SUPERSTAR CAR WASH

EXTERIOR ELEVATIONS

Sign Plan_V1.pdf Markup Summary

3 TYPICAL BUILDING SIGNAGE DETAIL  
SCALE: N.T.S.

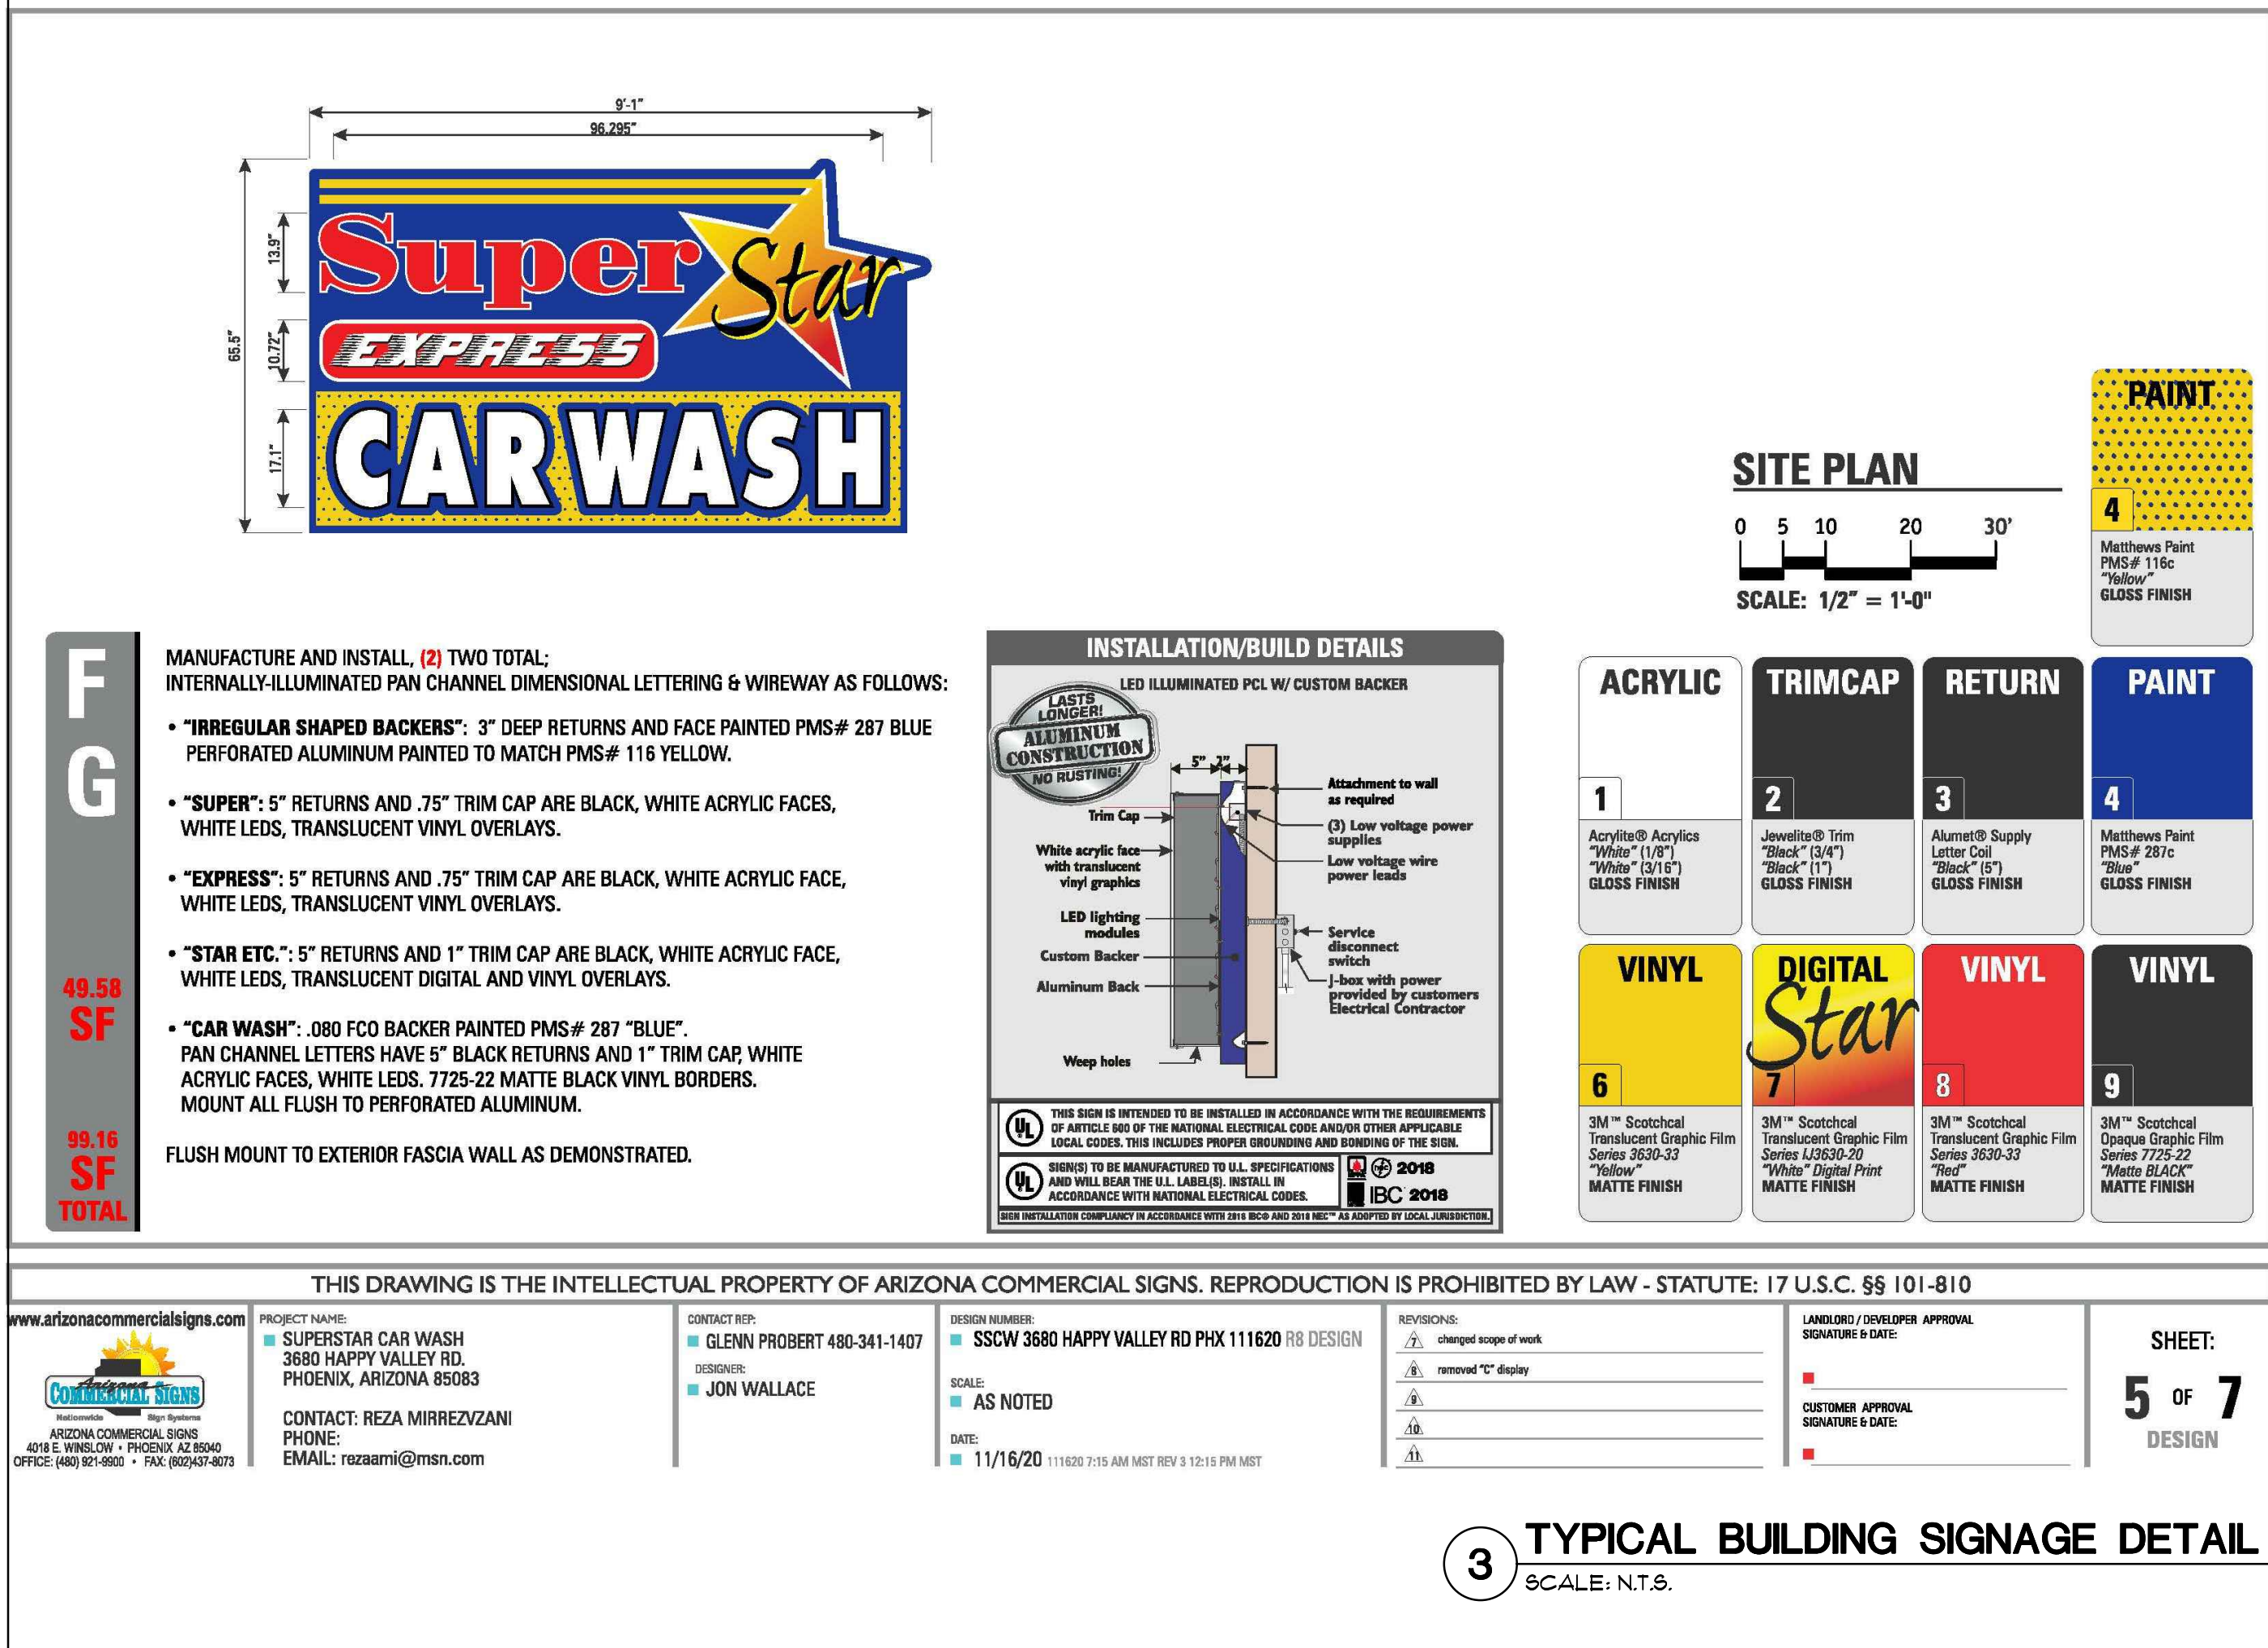
Please show signage dimensions for all proposed signage throughout site.

(c) Attached Signs.
 (i) Maximum Sign Area Per Building Wall. The total area of attached signs per building wall including wall signs, fascia signs, awning signs, canopy signs, hanging and projecting signs shall conform to the following requirements:
 • Building Walls within 300 Feet of Lot Line in Commercial Zoning Districts or Industrial Zoning Districts. For building walls located within 300 feet of a lot, parcel, or tract line in commercial or industrial zoning districts, **1 1/2 square feet of attached signage is allowed per linear foot of building wall, or 300 square feet, whichever is less.**

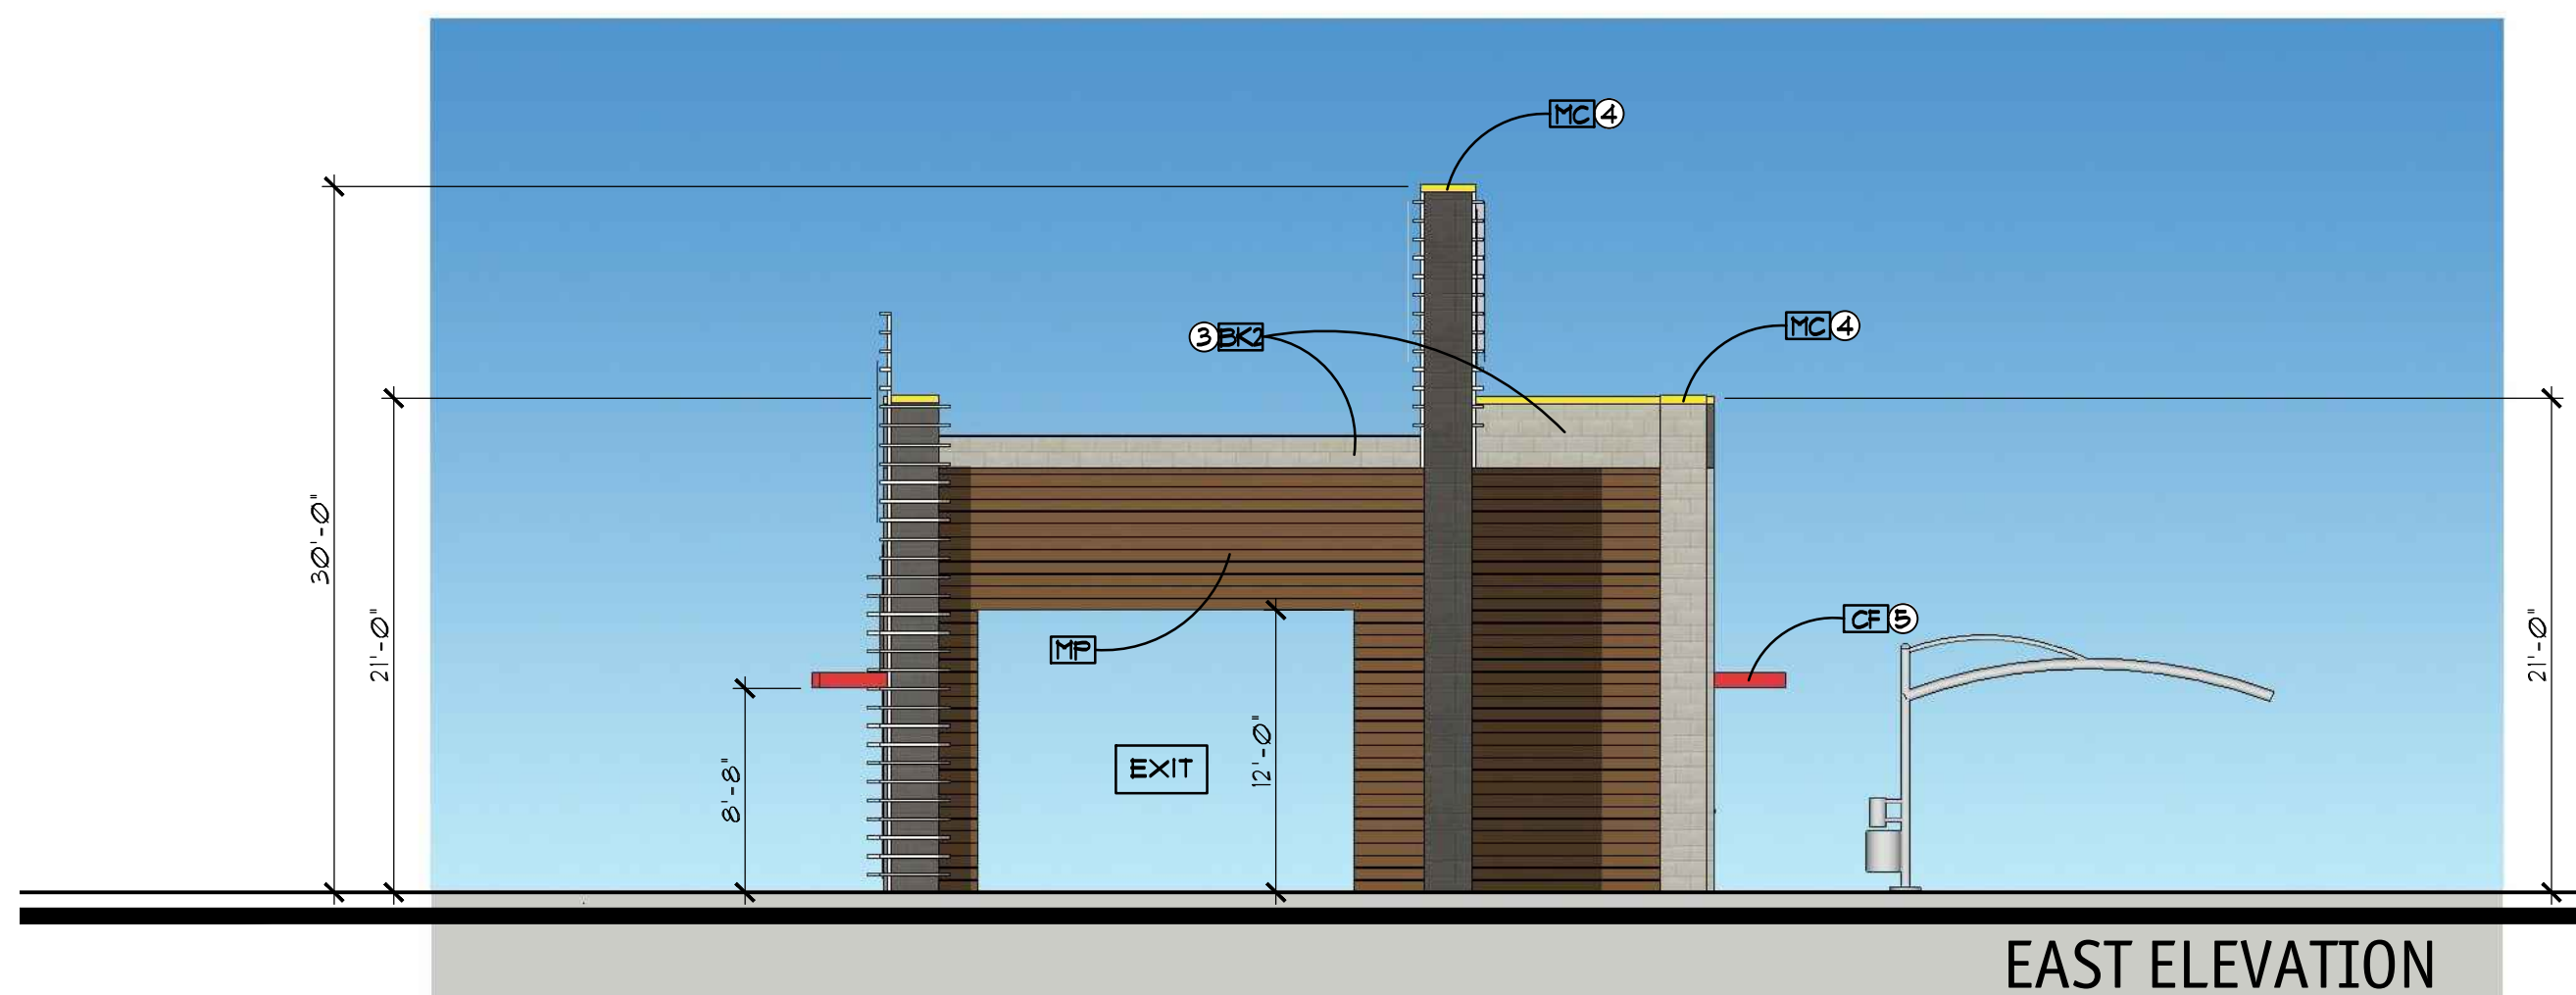
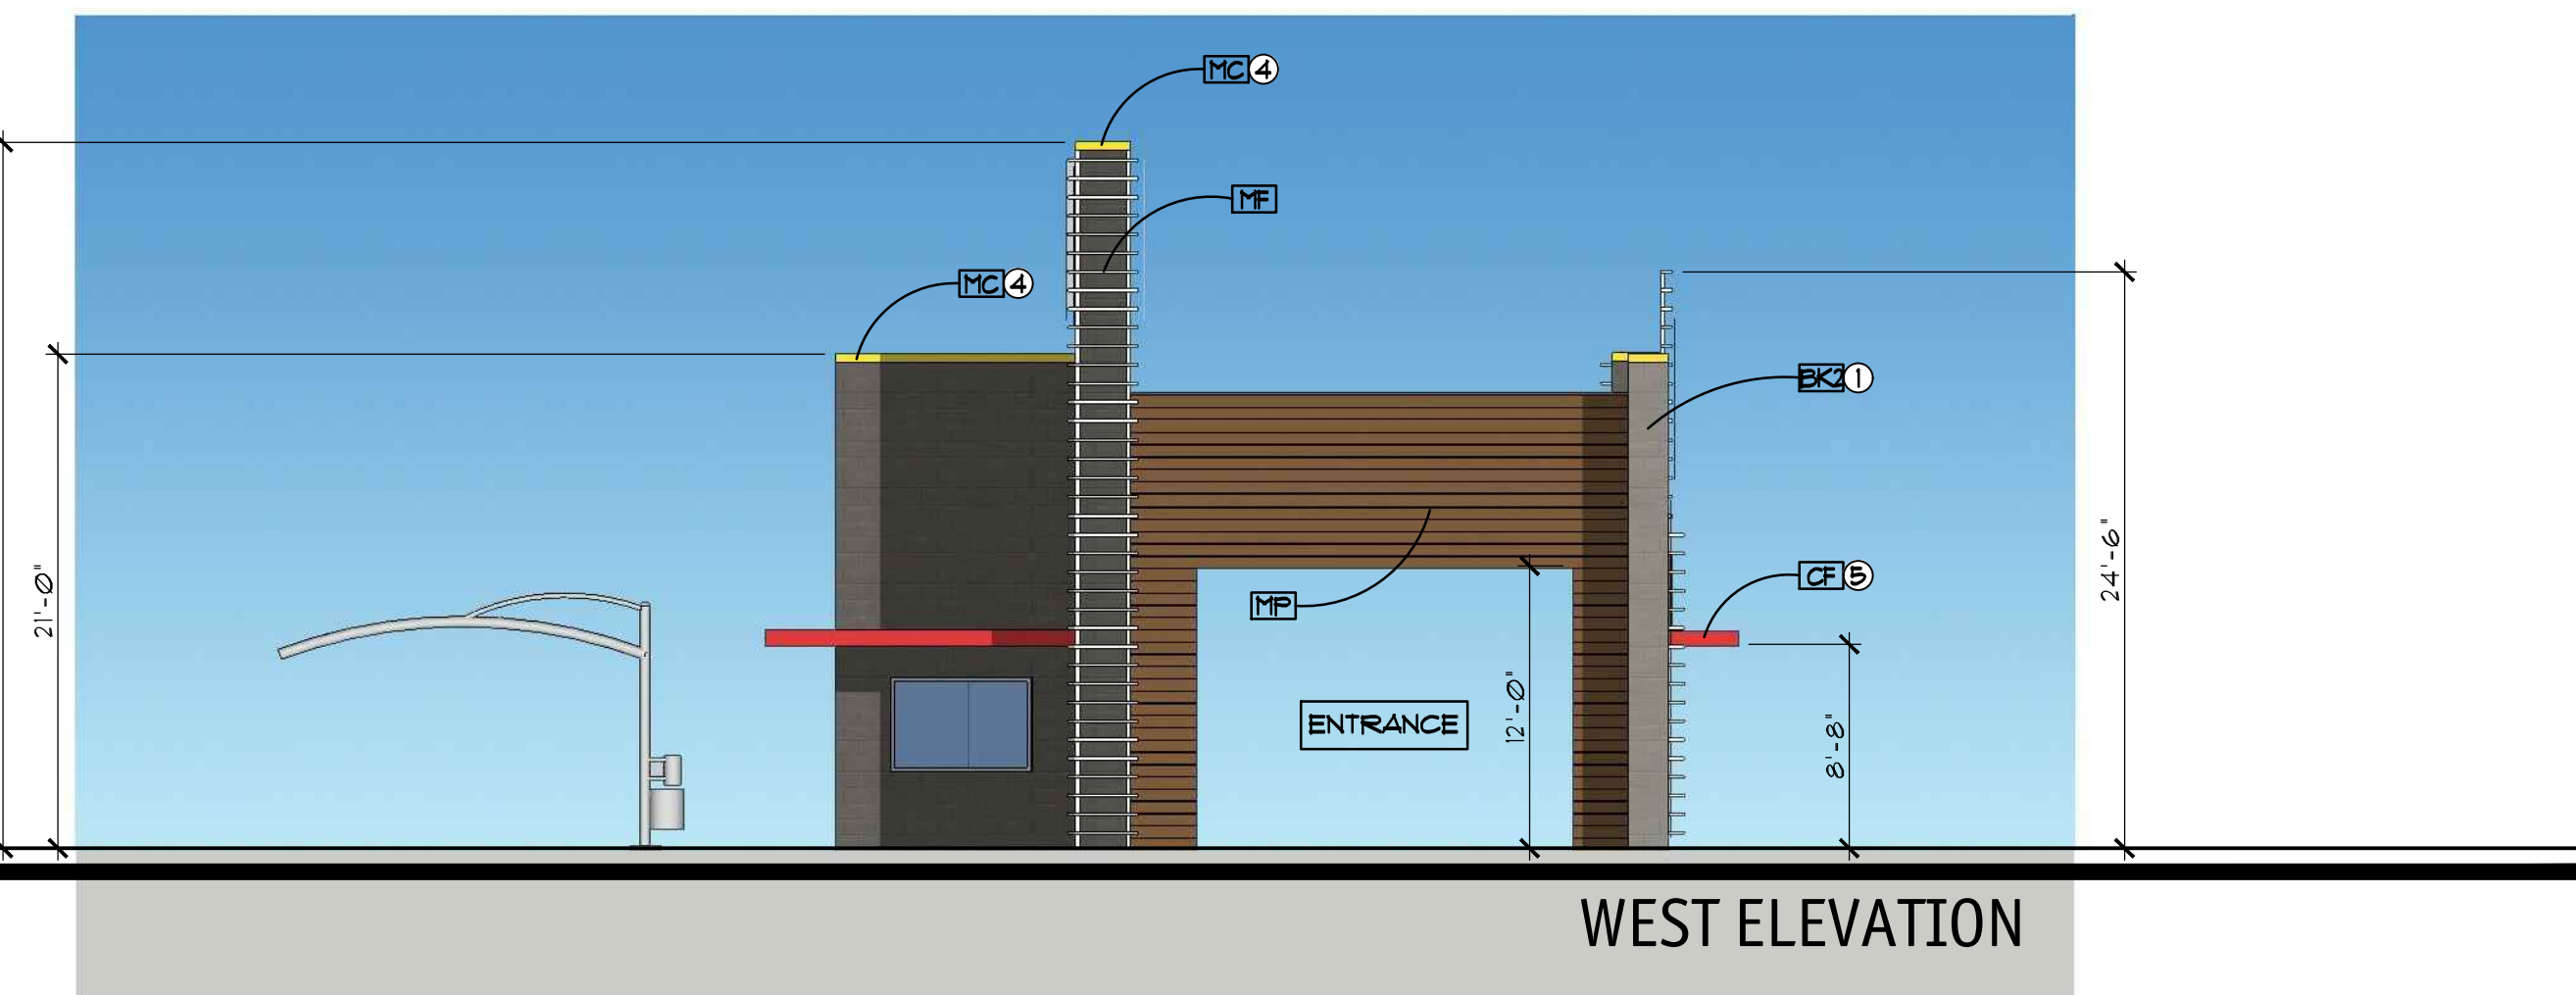
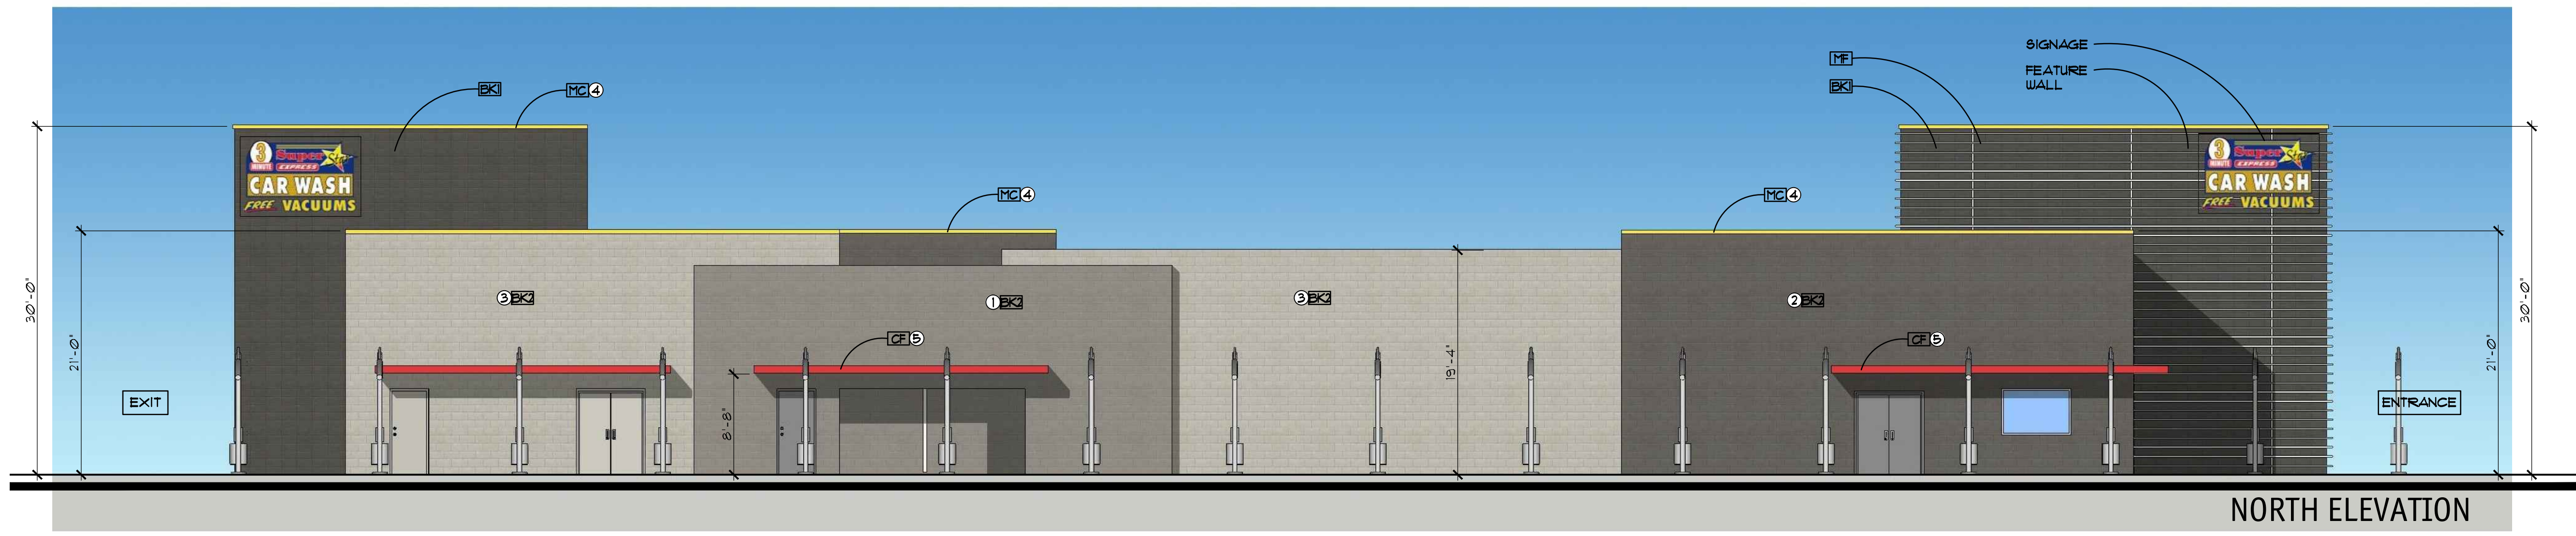
Please show signage dimensions for all proposed signage throughout site.
